About the application

Application number: 2026/91063	
What is the application for?:	Re-instatement and repair of existing building including alterations to roof and
Address of the site or building:	382, Huddersfield Road, Mirfield, WF14 9DL
Postcode:

User comments

Existing East South East Elevation (Right)
1 : 50

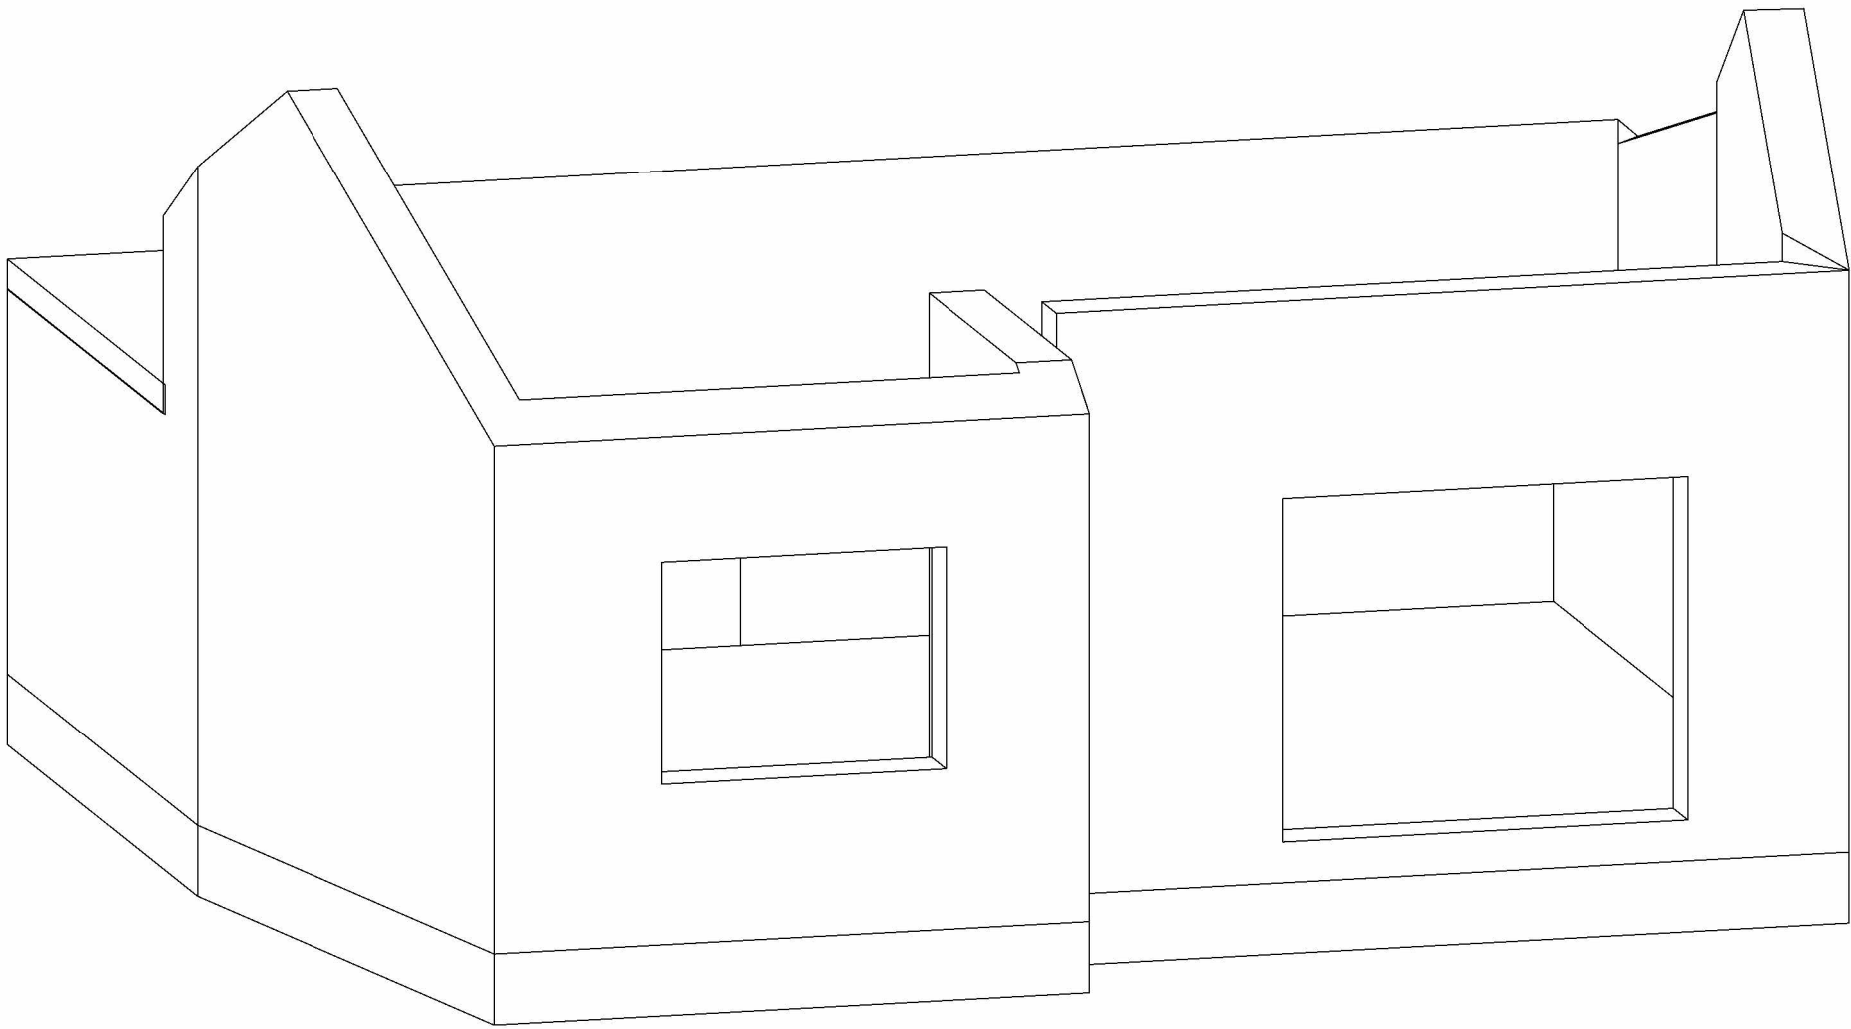
The existing that has been built without planning permission .

The as built now without planning permission is 5231mm

Drawing Number: TR-A25-0705-A3
Scale: 1 : 50@A1

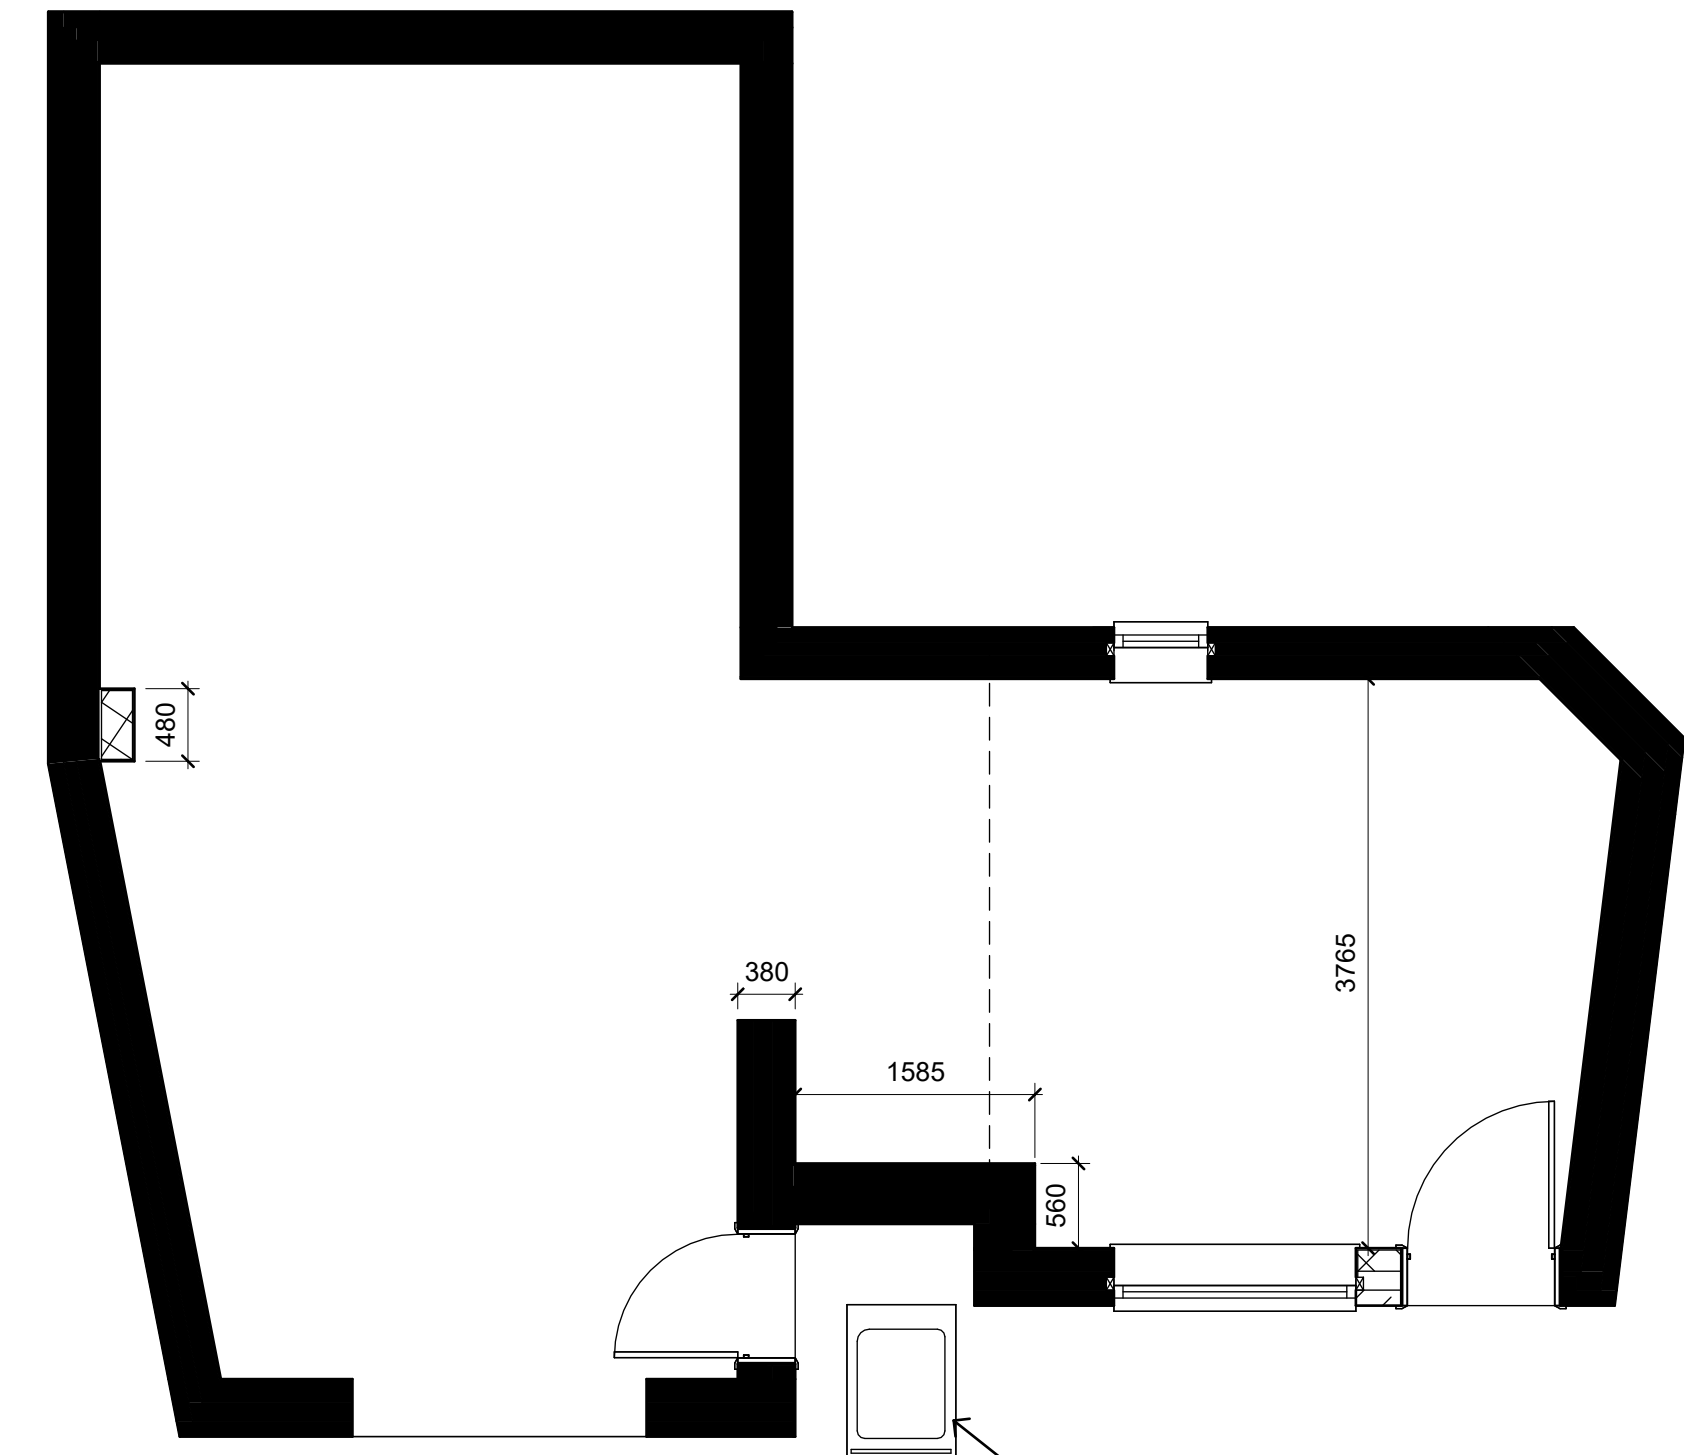
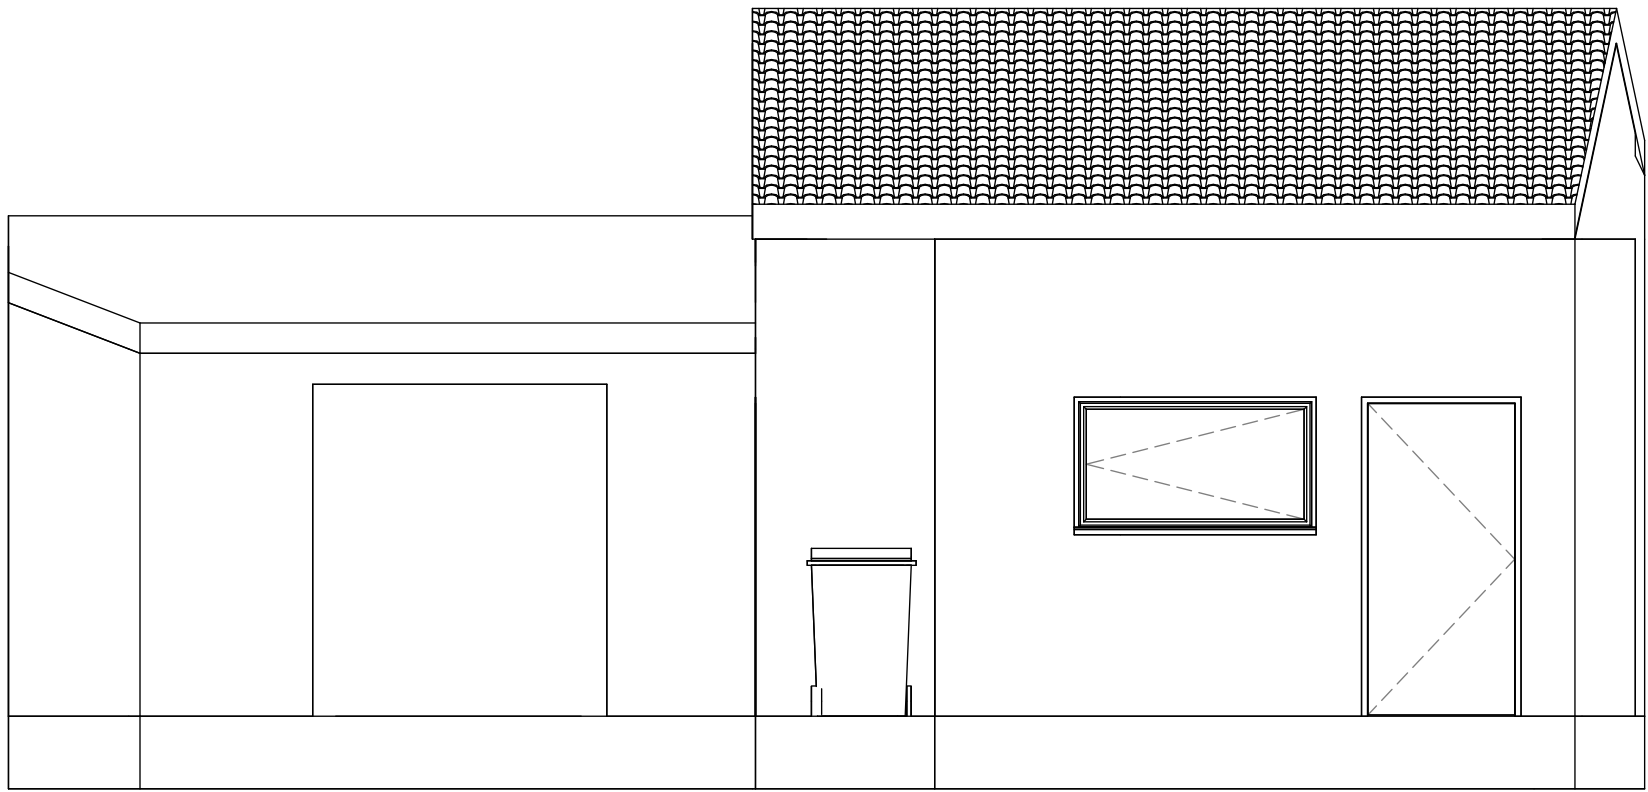
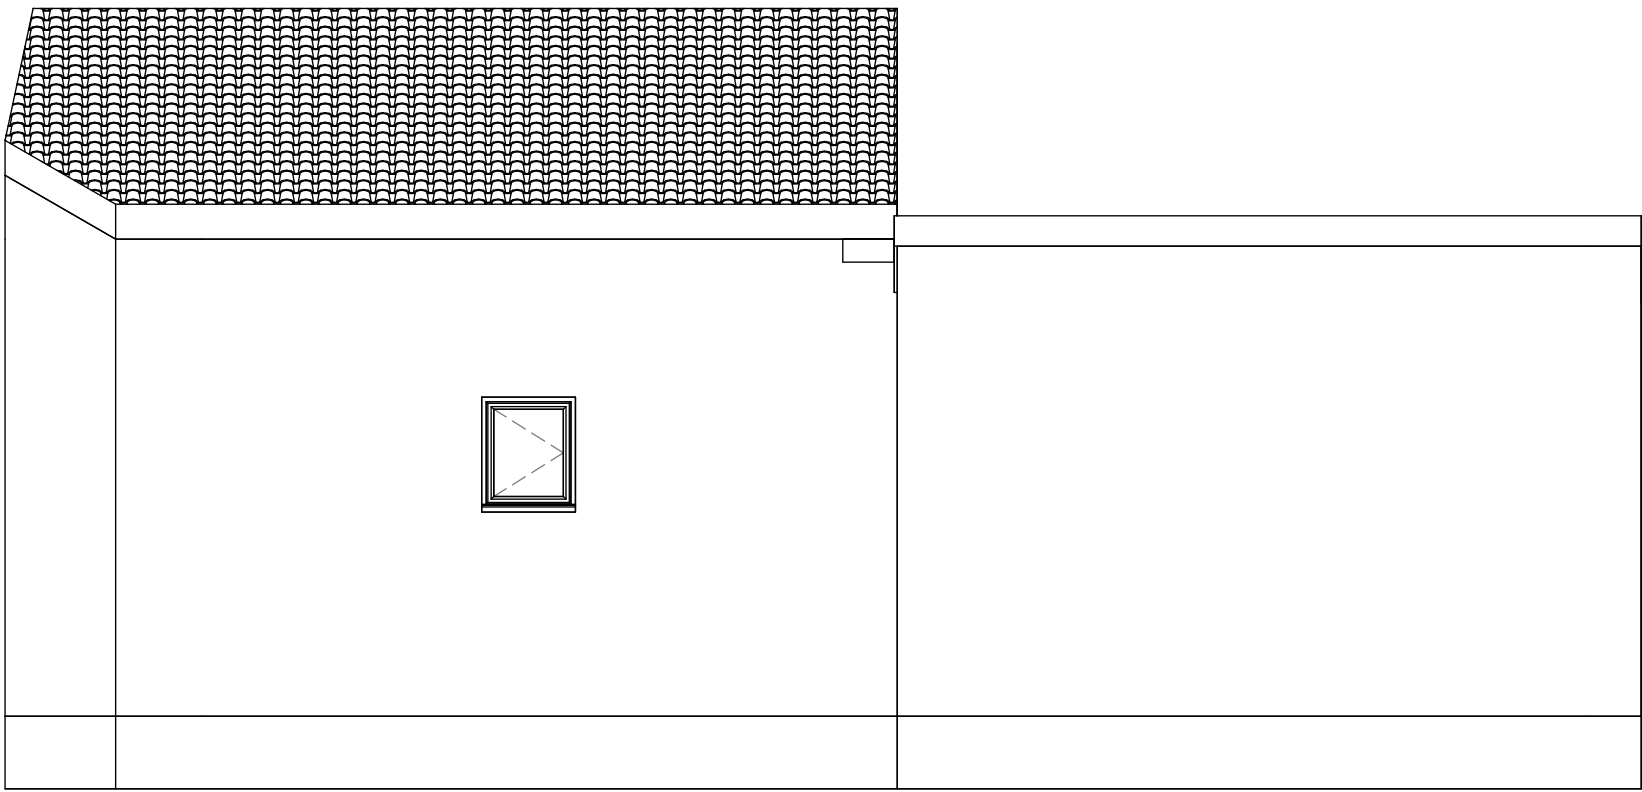
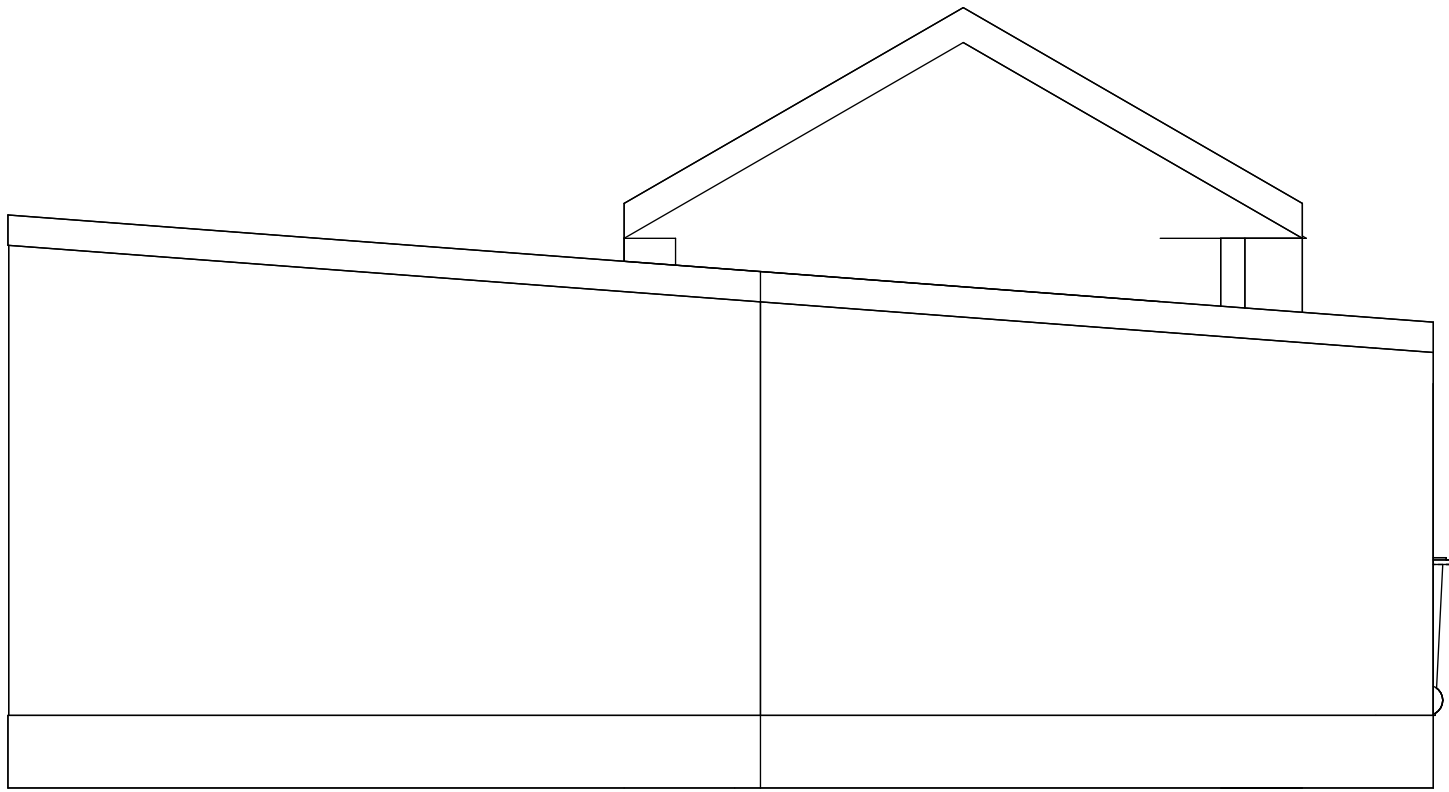
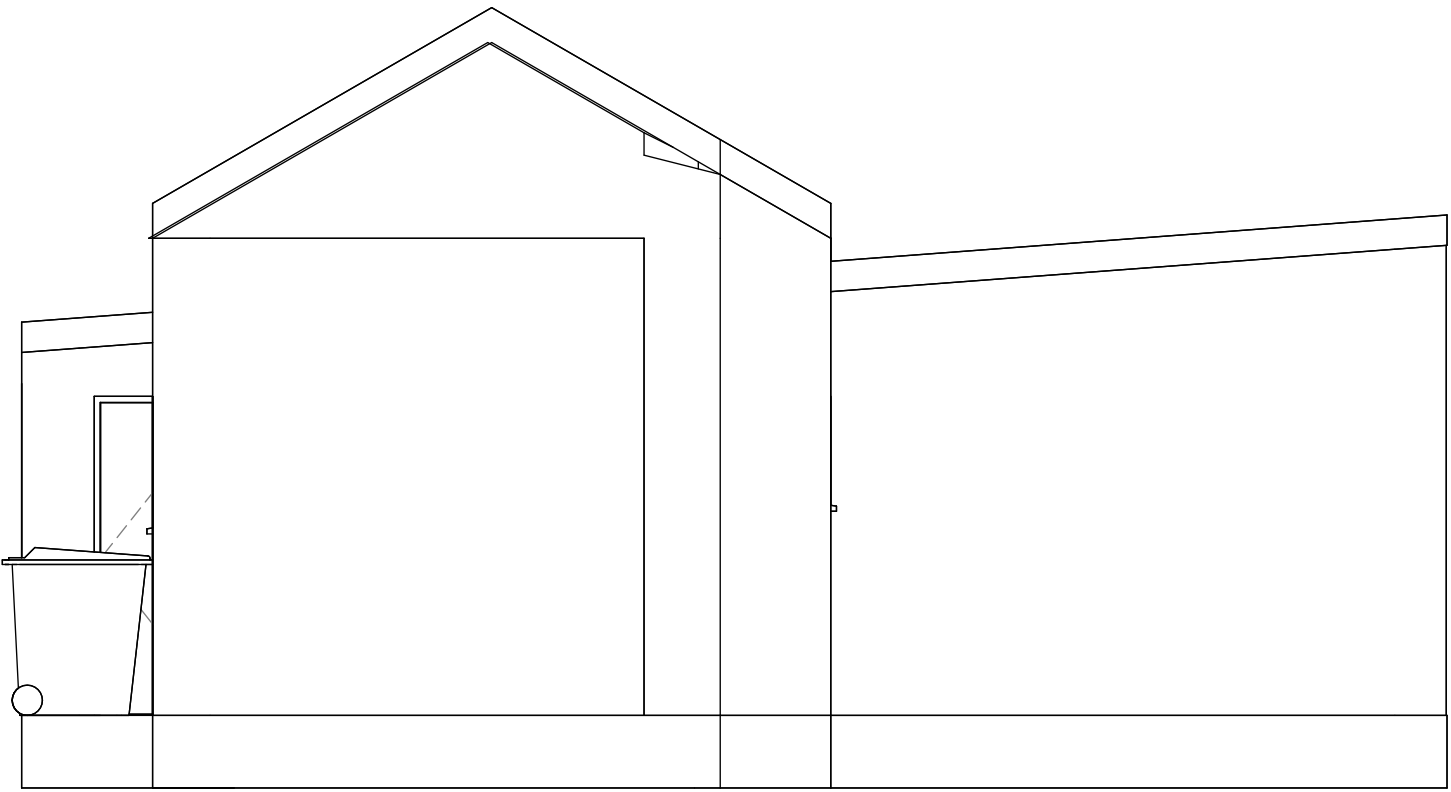
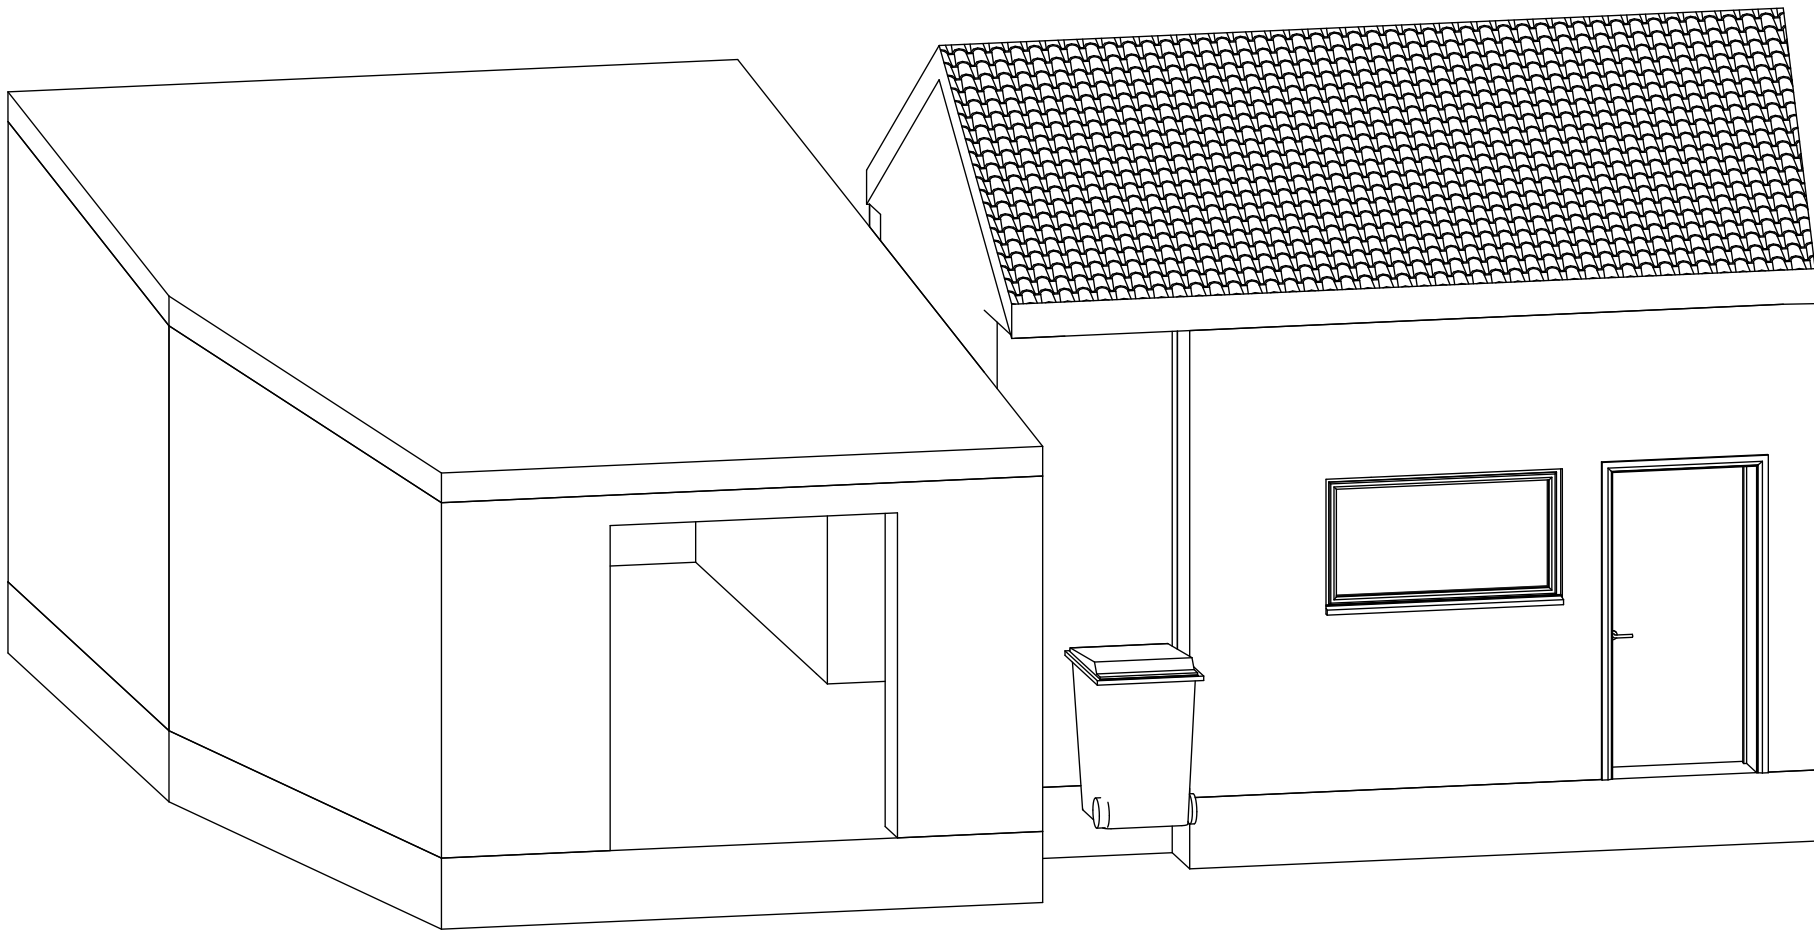
The existing. previously

There is no heights of the previous building.
